Application: SSI 7485

I write regarding the proposed modification to M4-M5 Link, Mod 2 The Crescent overpass and changes to pedestrian infrastructure in North Annandale, Rozelle and Rozelle Bay Foreshore area. *I object to the modifications proposed*

Figure 4-2 Pedestrian and cyclist bridge infrastructure options

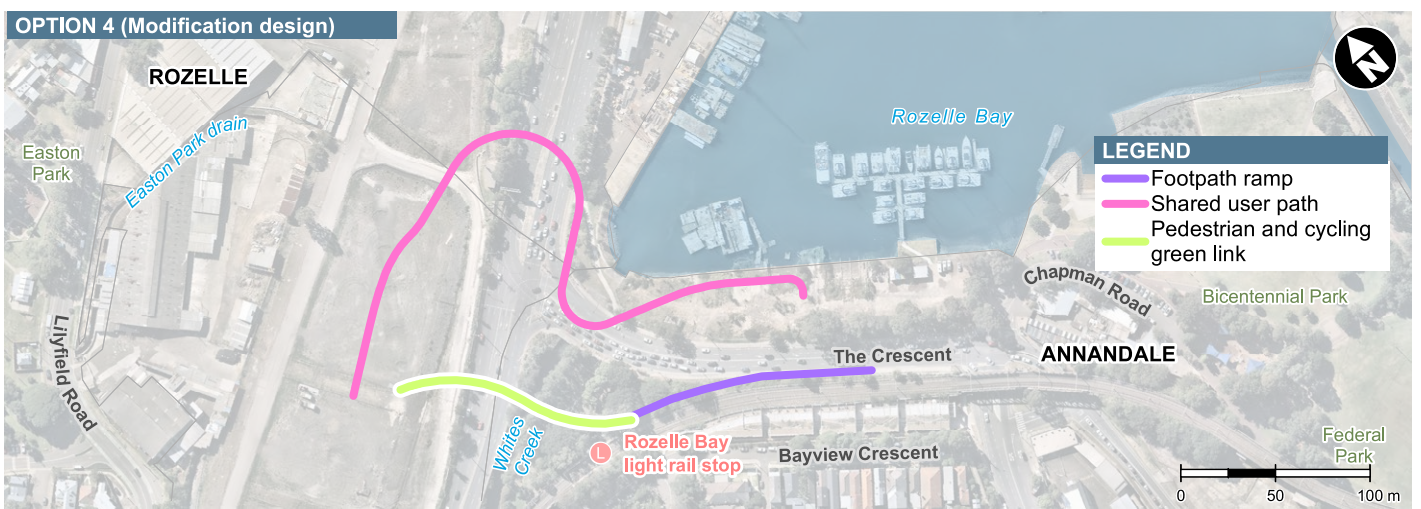
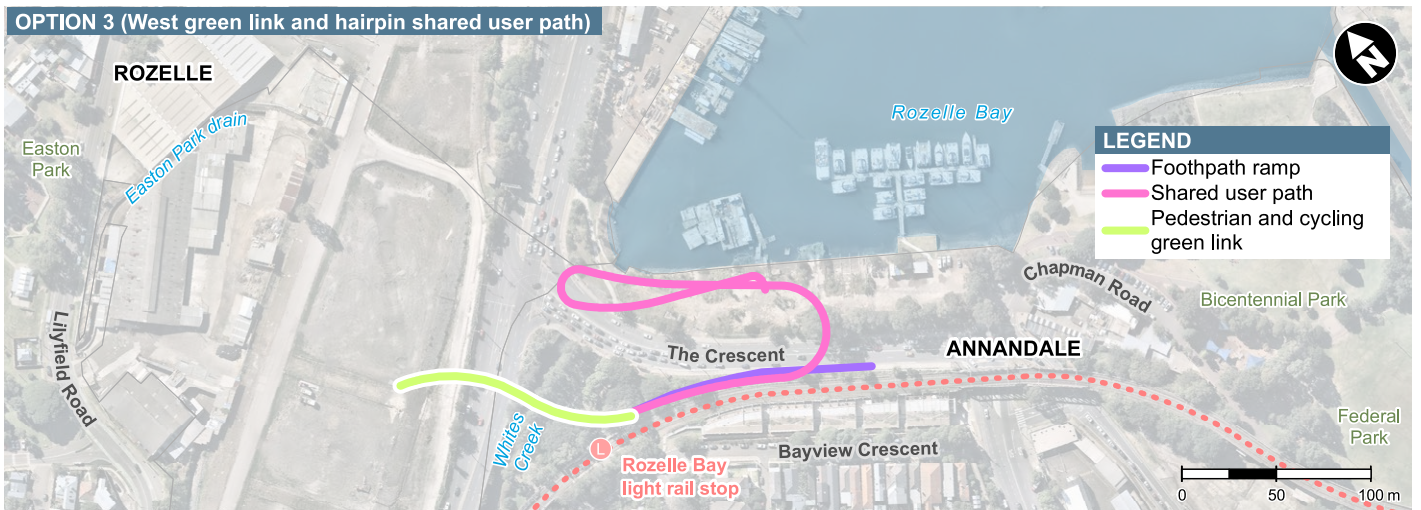
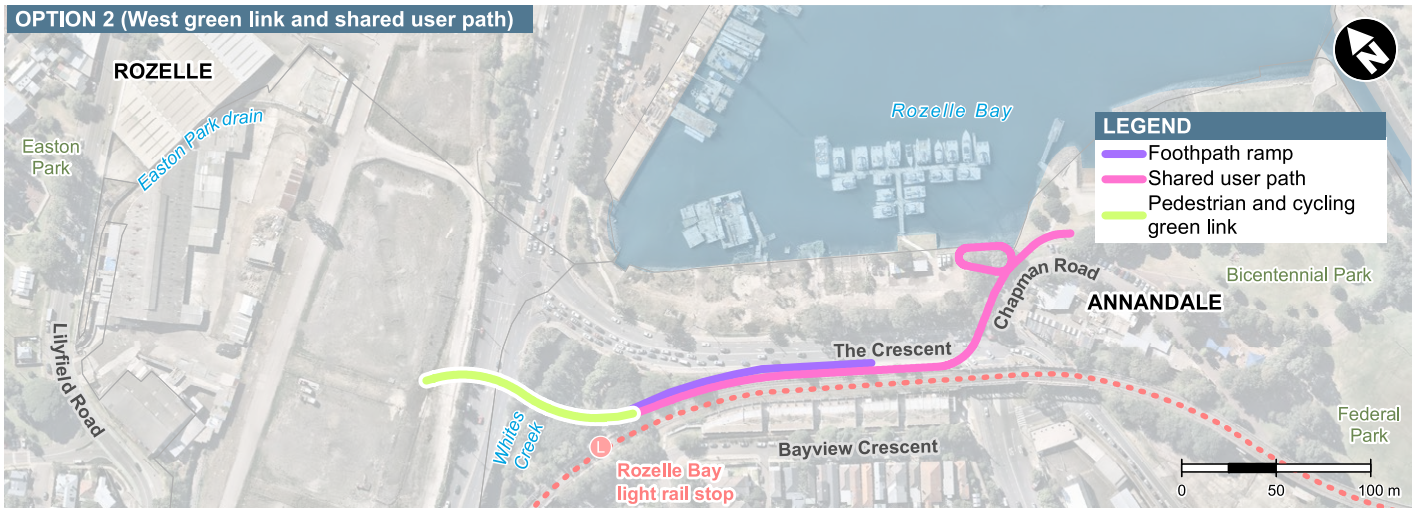
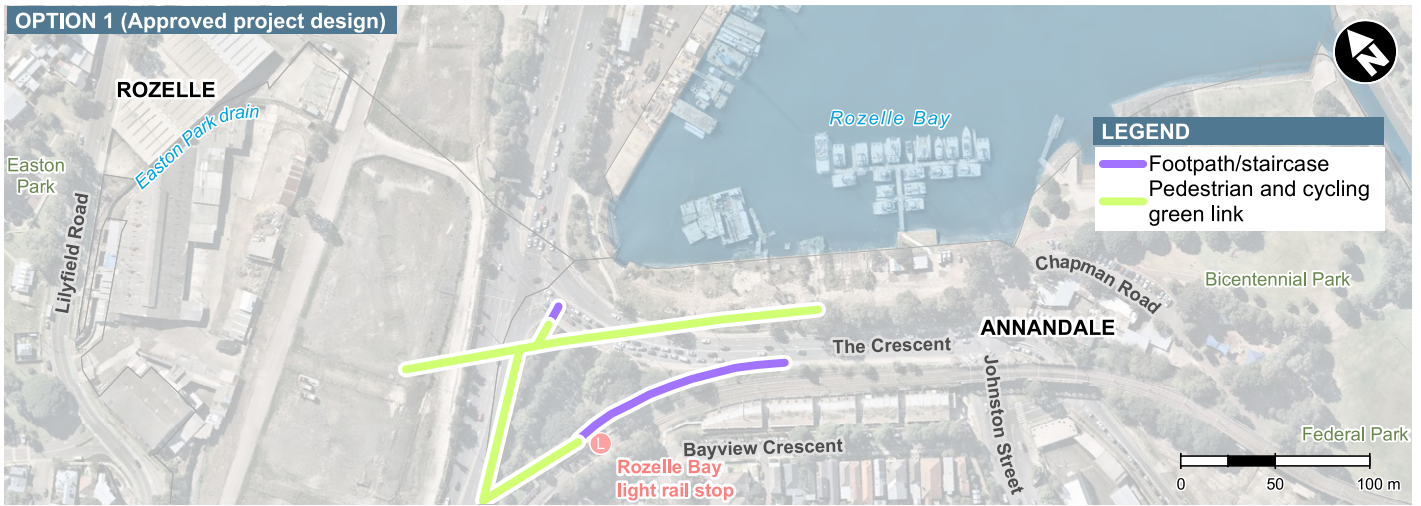
and I request RMS work with the community to explore alternate design options to the proposed new car overpass design and the changed pedestrian and cyclist links. I am seeking the reinstatement of the safe, direct access from the approved EIS GreenLink to create a continuous green open space connection from the Rozelle Rail yards and Annandale to the foreshore. The GreenLink was more than just a walk way - it put people central to the design, maximising safety, and providing much needed accessible open space for the community now and into the future Bays Precinct design.

- The significantly reduced safety and increased risk for pedestrians and cyclists with removed access over The Crescent to Bicentennial Park and the increased traffic along Johnson Street.
- Being required to cross five sets of pedestrian lights at The Crescent as my option to reach the foreshore from Annandale or from Rozelle Bay light rail stop.
- Removal of direct active links to the foreshore, cutting the community off from the area and the proposed revitalisation of the entire Bays Precinct, including linking the Light Rail and Bus stops to a Ferry wharf and Metro station.
- Urban and landscape design that is being built before a finalised Masterplan for the area.
- Traffic changes that limit movements around the suburb and create further congestion in the local streets of Annandale, Forest Lodge, Glebe, Lilyfield and Rozelle with no planning to deal with these.

- Reinstate the GreenLink connecting communities and green open space from Rozelle to Bicentennial Park
- Relocate and design pedestrian and cyclist connections that are continuous, safe and direct.
- Design the modification infrastructure and active links in response to the character of the suburbs, the location of the foreshore and it's potential future development.
- Provide pedestrian and cyclist paths that maximise people safety and do not force them onto busier streets, unsafe concrete plazas and caged walkways.
- Integrate active and direct connections to all active transport - including the future Metro West and Foreshore Ferry Wharf

Figure 4-6 Elevation: Indicative view of Rozelle Rail Yards Pedestrian and Cycling Green Link

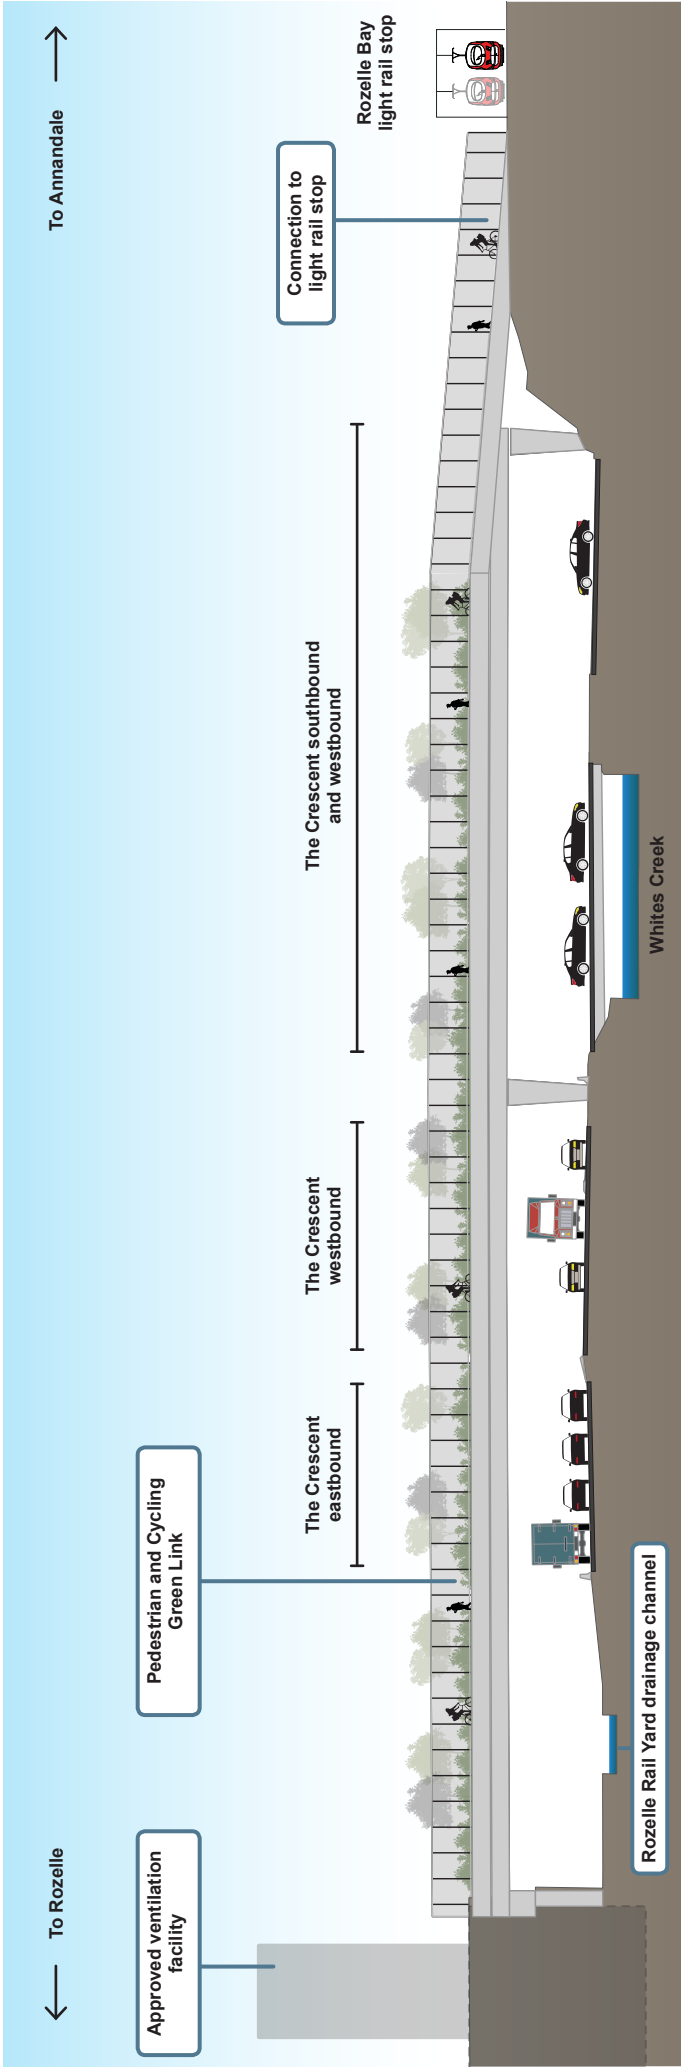
how you should cycle from ~~rozzelle~~ lilyfield to the city over the anzac. With the removal of the current lilyfield road / victoria road intersection pedestrian / cycle overpass. Will there be an underpass connecting the greenlink and anzac bridge cycle route? Going from the greenlink to the bays precinct (jubilee park) and then back to the anzac bridge cycle path is a significant delay overhead, especially on such a busy route.

a direct link (underpass / overpass) connecting Lilyfield road
greenlink to the anzac bridge cycle path / pedestrian
path.
